Addendum No. 1

RE: Contract ID C202565

Caldwell County (U-5204)

SR-1764 (New Farm Rd.) From SR-1764 (New Farm Rd.) To

REVISIONS						SHEET NO. S1-14
NO.	BY:	DATE:	NO.	BY:	DATE:	TOTAL SHEETS
1	MTP	12/2011	3			46
2			4			46

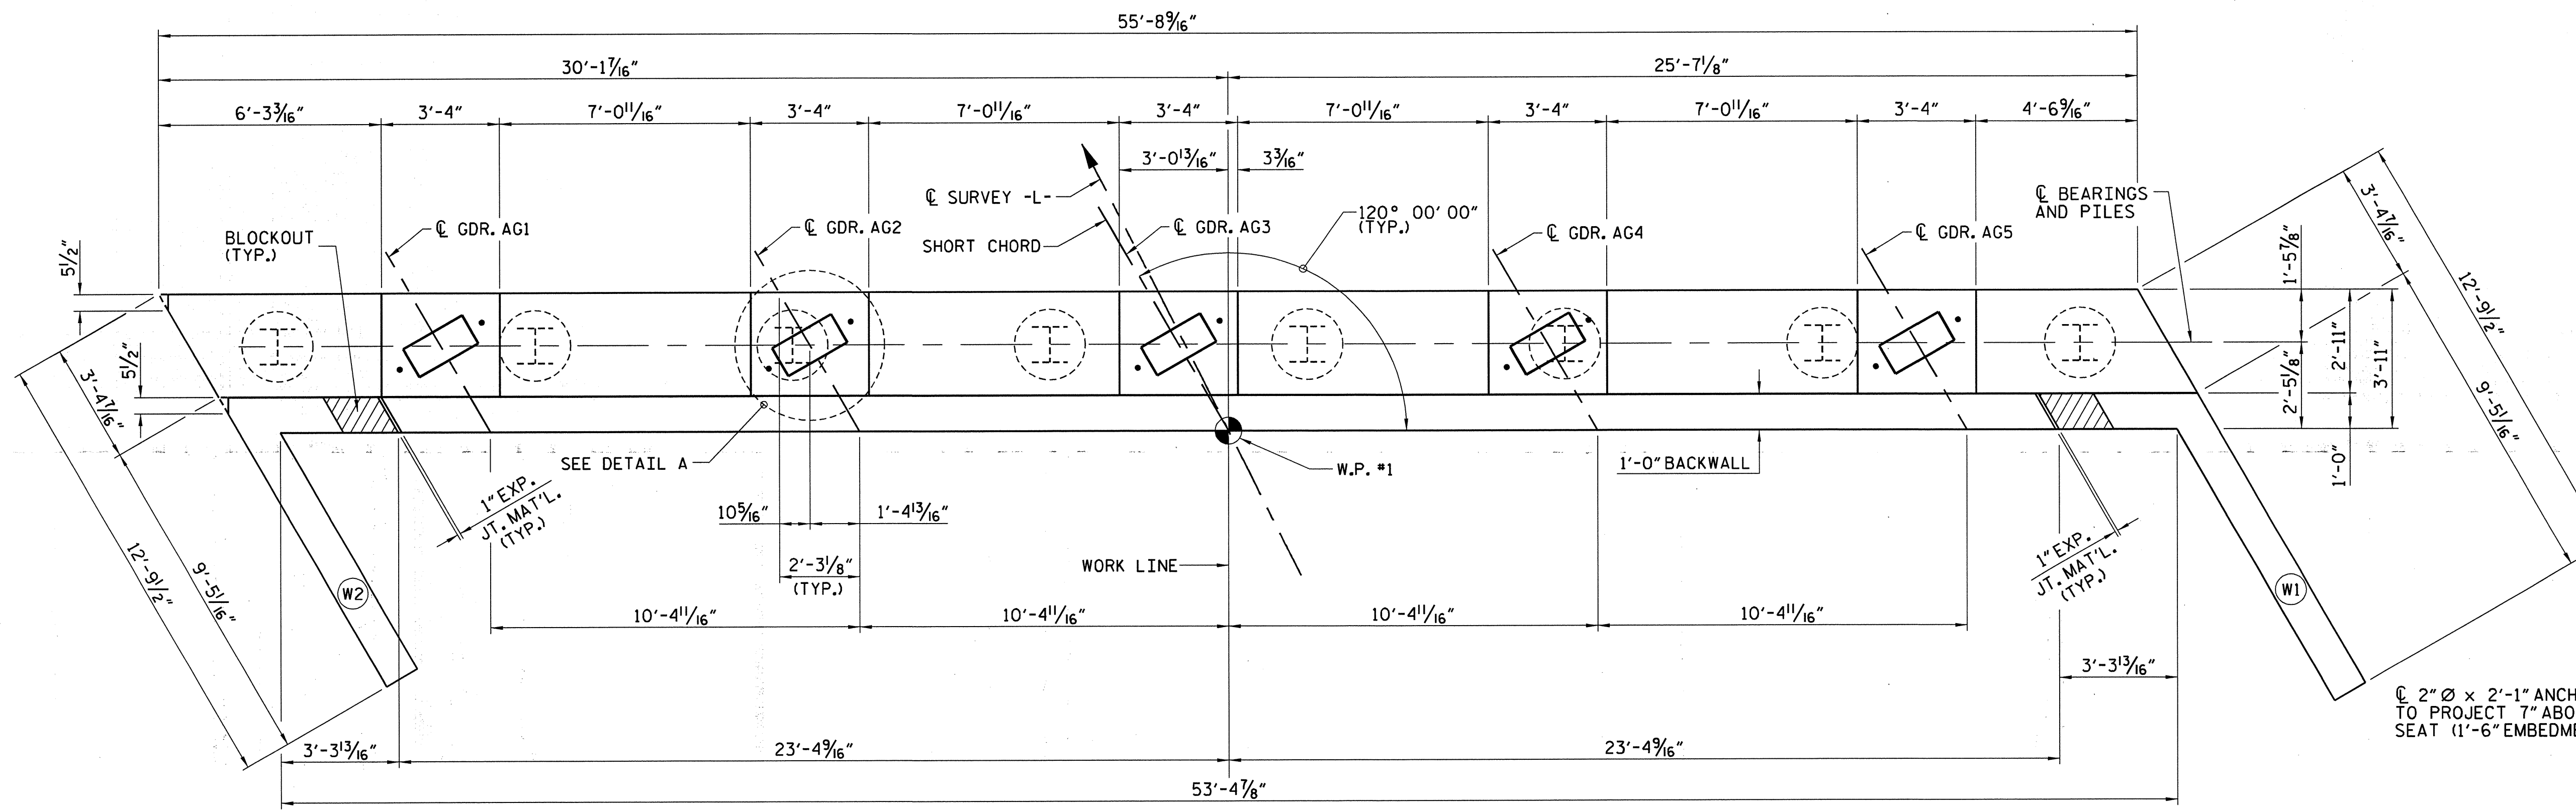
Sheet No. S1-14 has been revised to correct the reinforcing steel in the "Superstructure Bill of Material". Please void Sheet No. S1-14 in your plans and staple the revised Sheet No. S1-14 thereto.

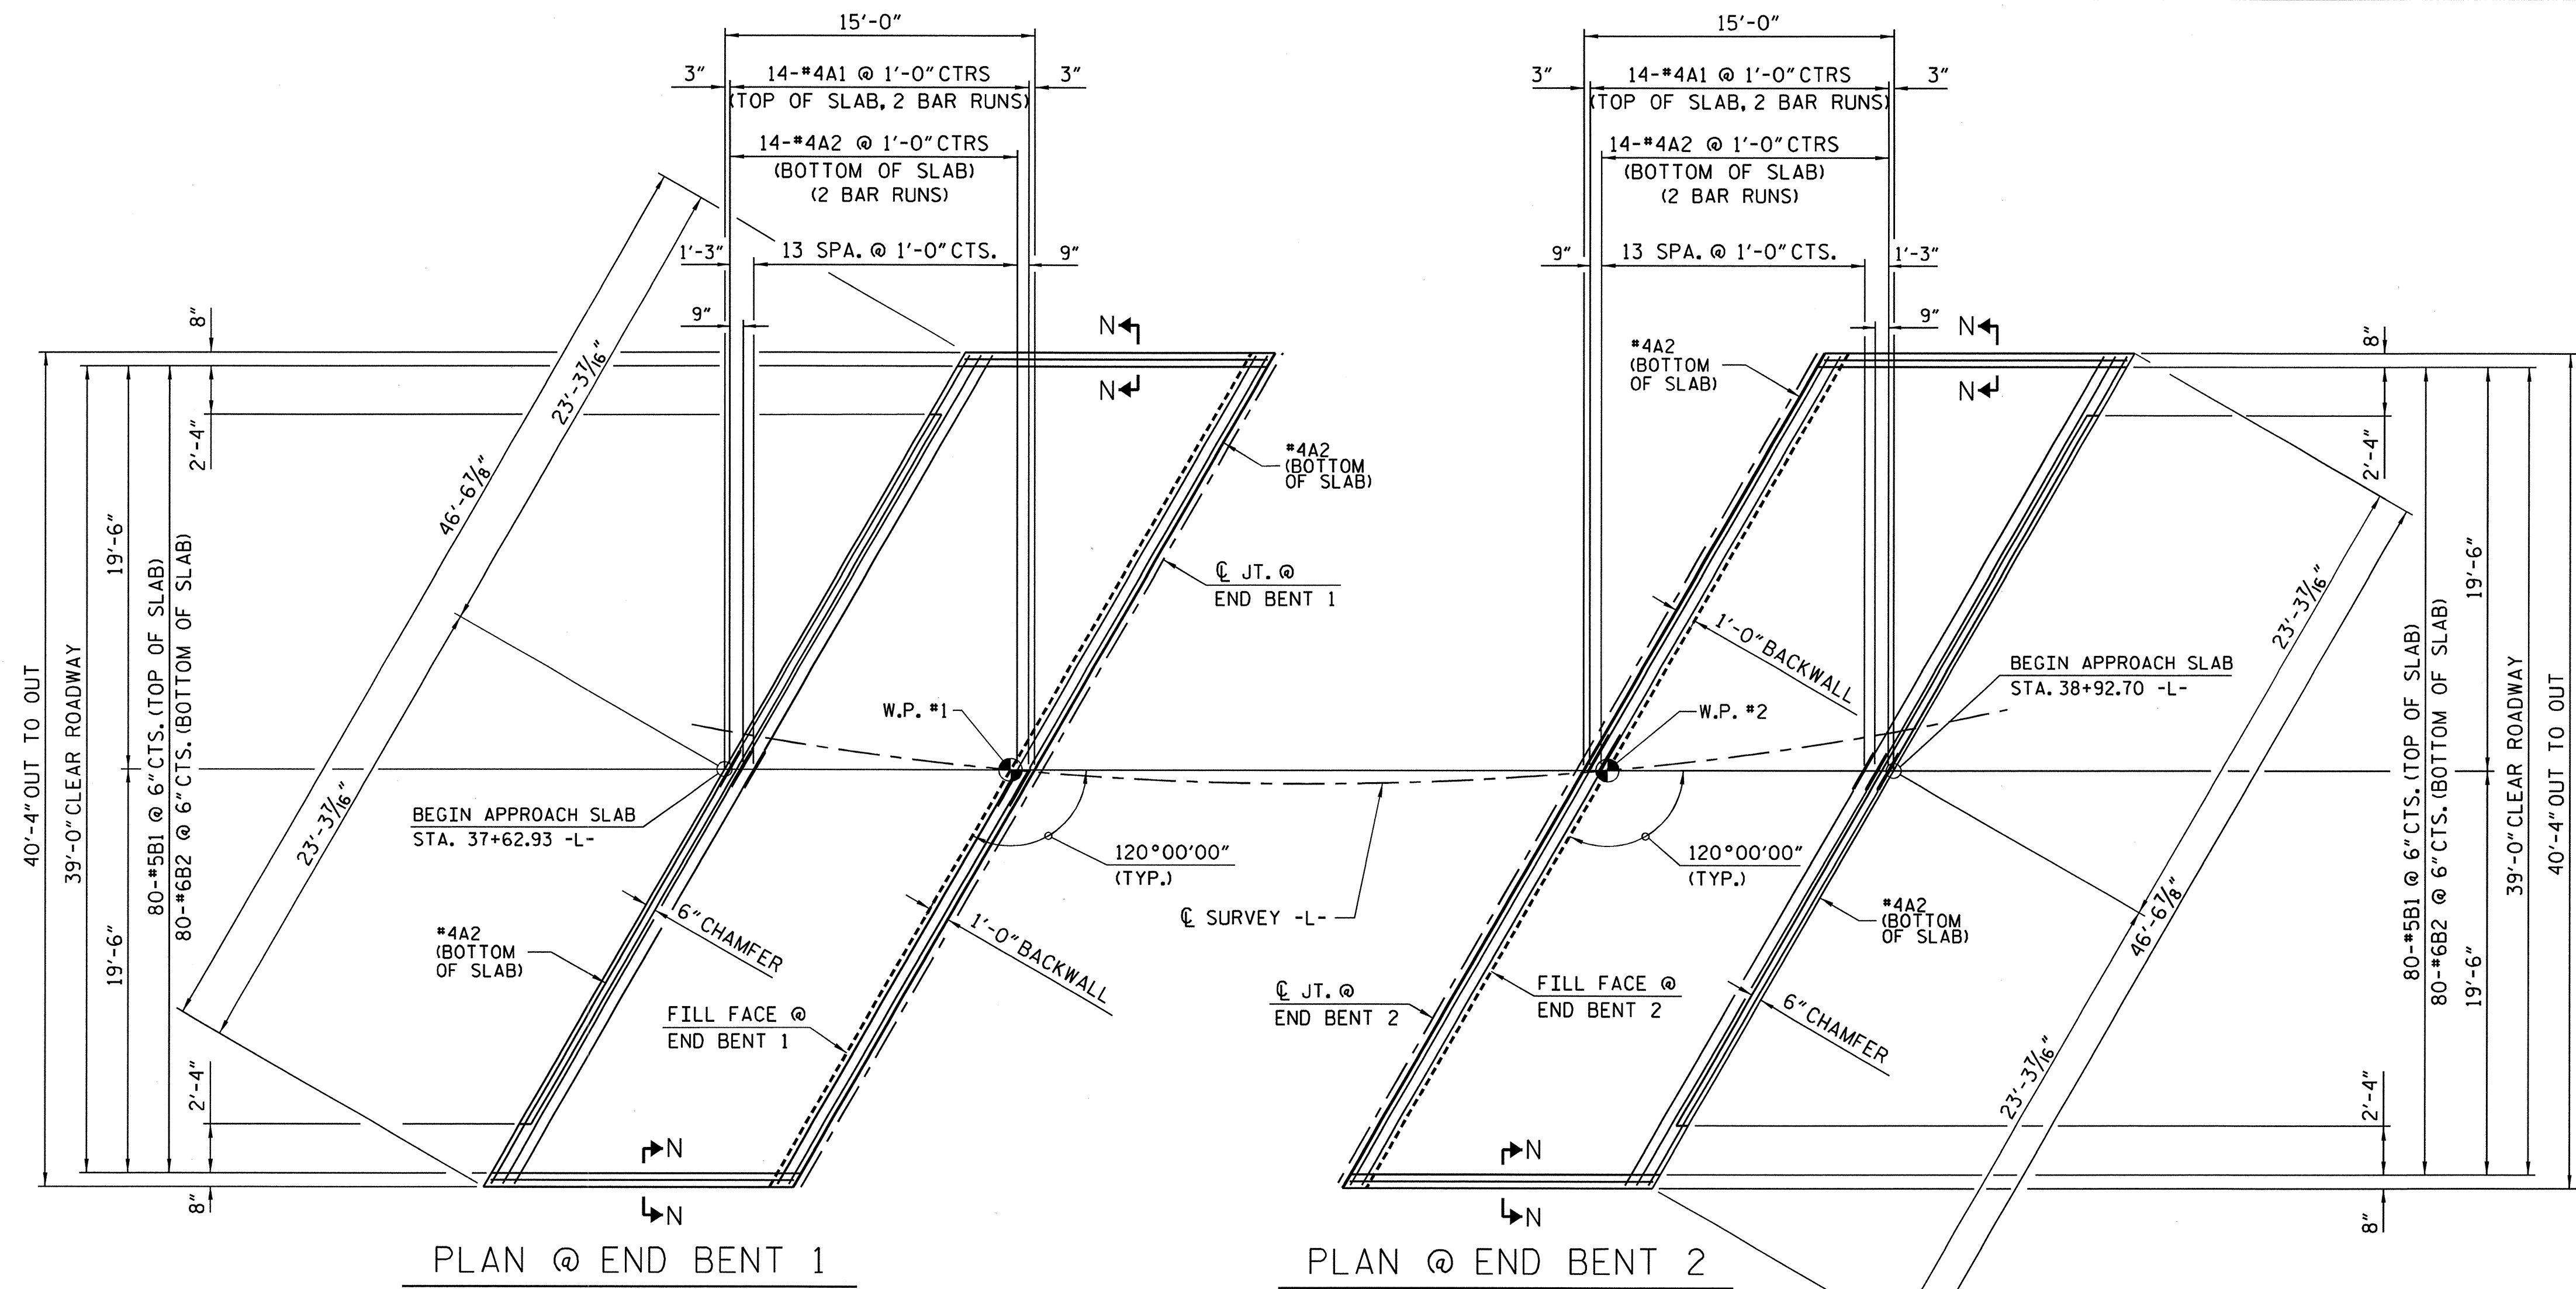
On Sheet No. S1-22 the "Section Thru Slab detail" was revised. Please void Sheet No. S1-22 in your plans and staple the revised Sheet No. S1-22 thereto.
